PLANNING CONSULTATION RESPONSE

Application No	2026/0535
Proposal	2026 0535 Erection of Extension to Existing Detached Garage Replace Flat with Pitched Playroom Roof Hudroyd House Genn Lane Ward Green
Address	Hudroyd House Genn Lane Ward Green
Date of Consultation Reply	130726
Consultee	Tony Wiles Senior Conservation Officer

Ground Floor Layout
as Proposed.

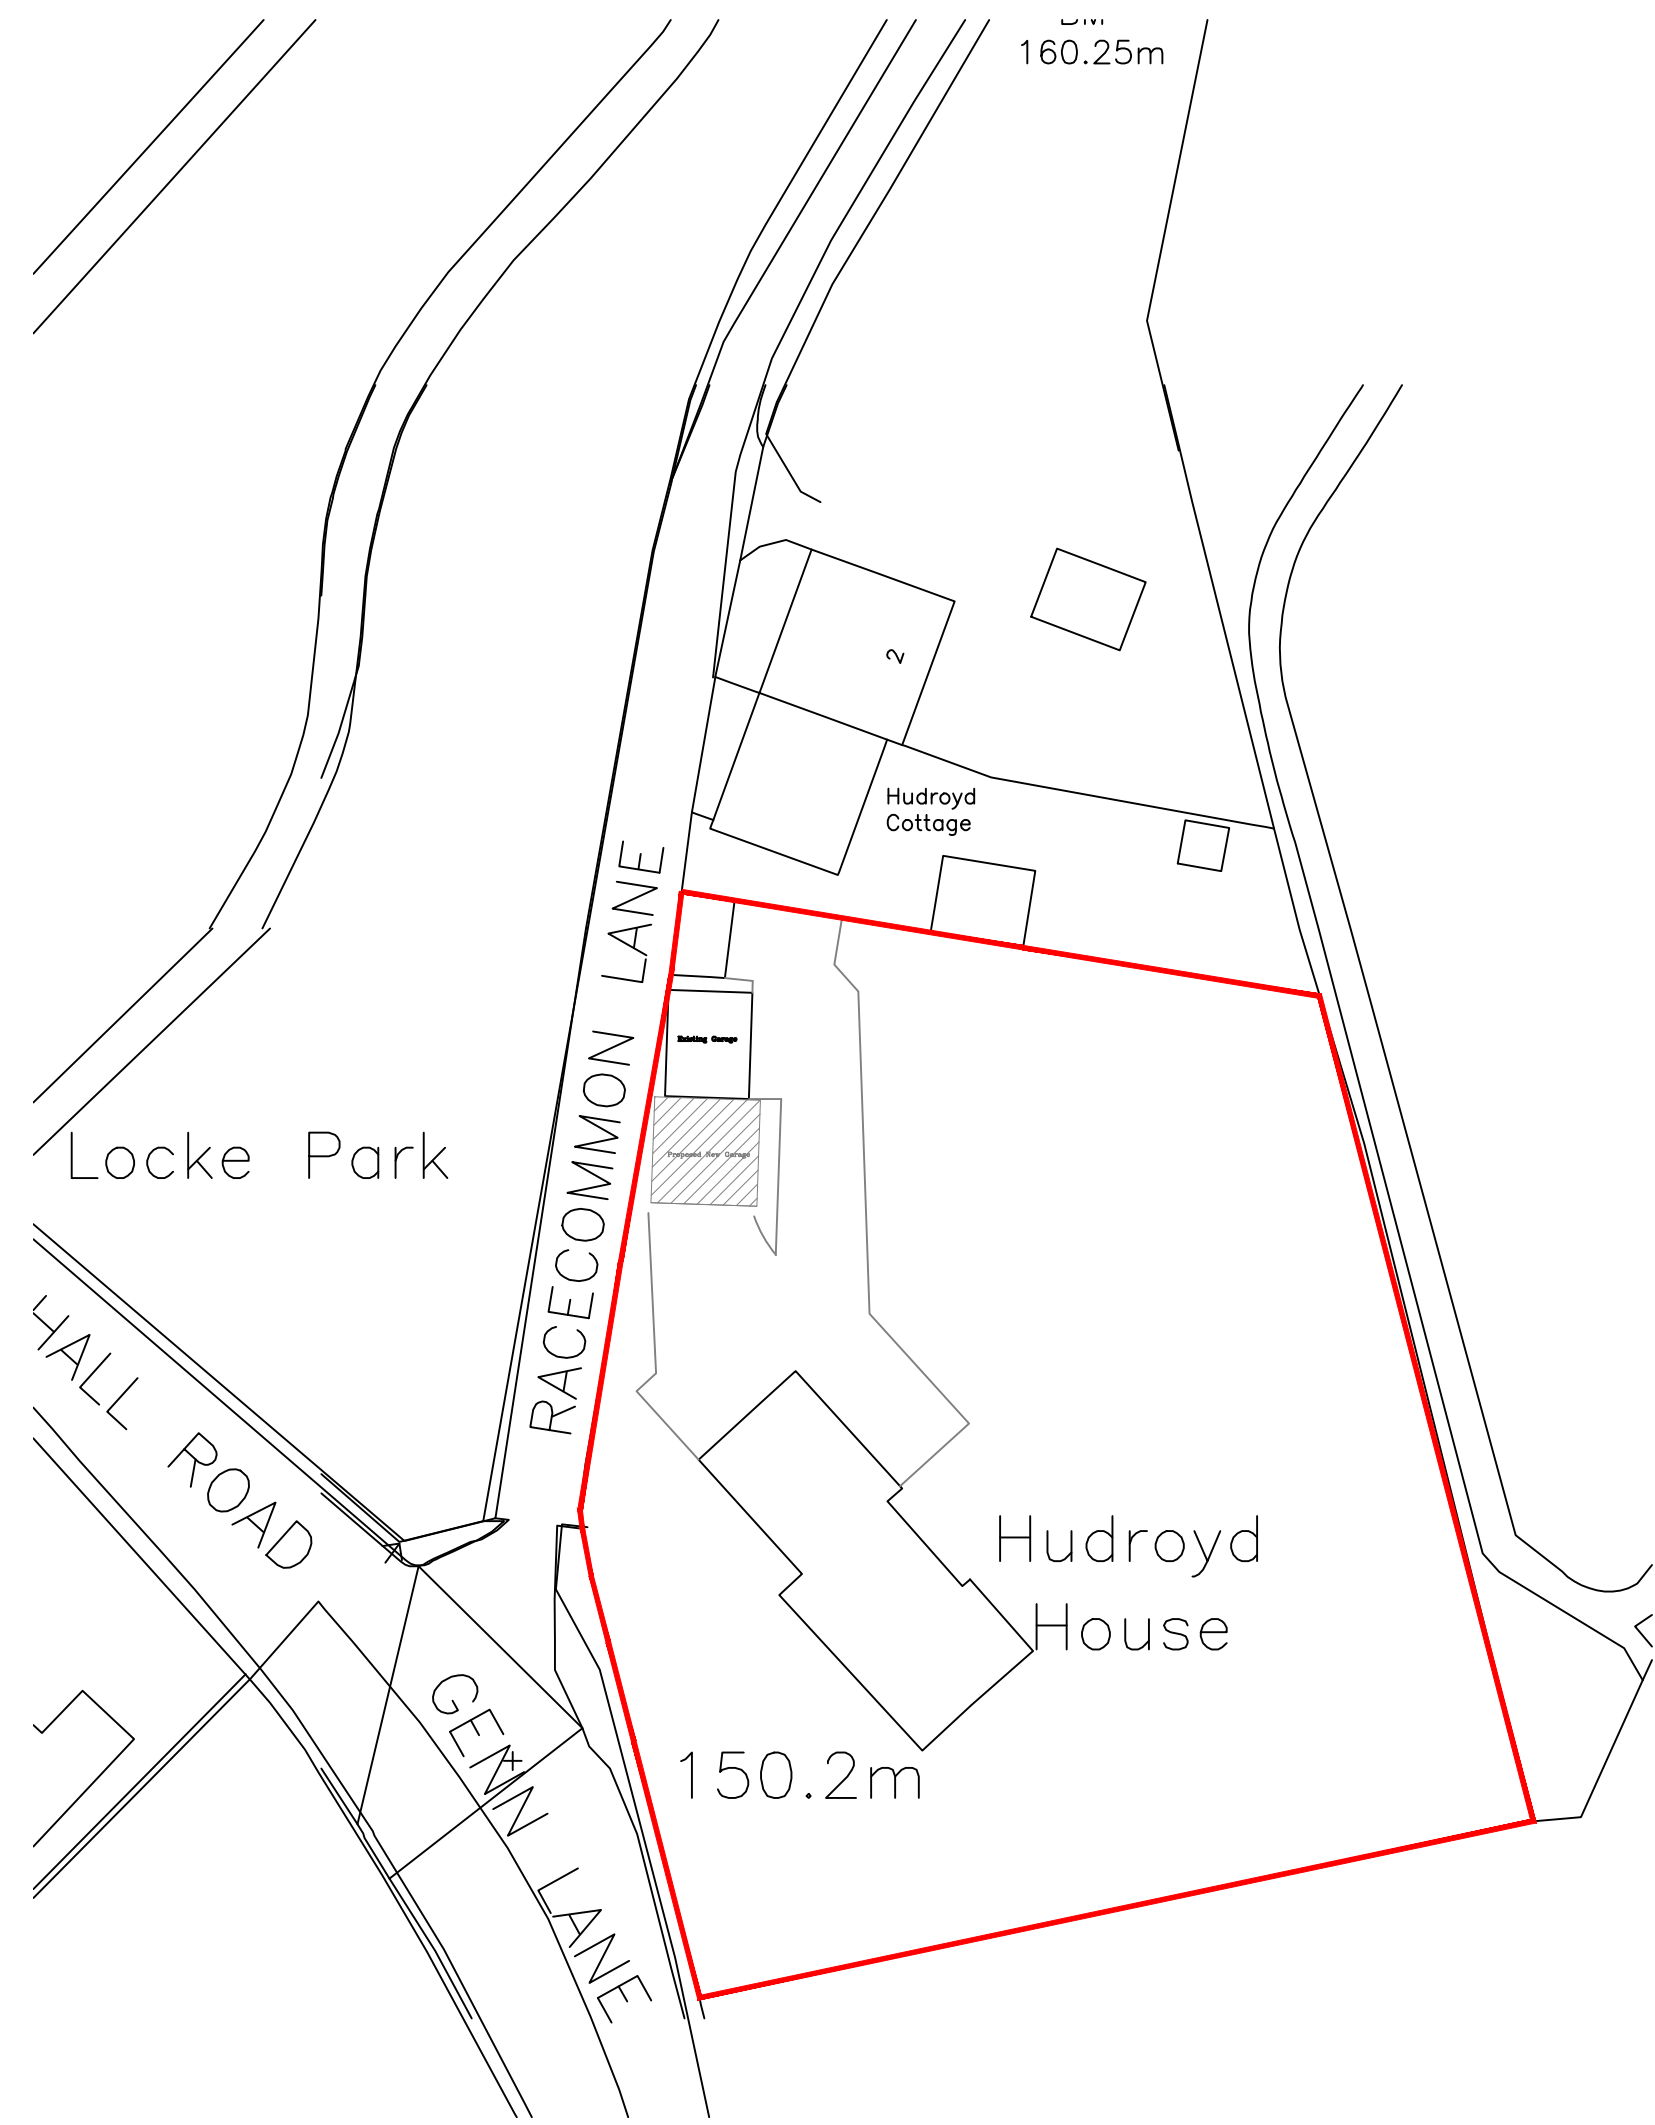
The materials used in the construction of the garage walls shall match those used in the construction of the existing garage including stone type, colour, face dressing and pointing detail

The roof shall be covered using either a natural stone roofing slate or blue/grey slates or good quality riven artificial alternative that emulates this closely and shall be laid in diminishing courses with matching ridge tiles

The rooflights used in the development shall be conservation specific rooflights, low in profile, vertically emphasised, with a single vertical divider, and decorated black.

The doors of the Juliet balcony in the southern gable shall utilise dark grey frames which shall be mounted a minimum of 100mm in the reveal. The glazed balustrade shall be affixed directly to the stonework using glass clamps or a similar unintrusive fixing method
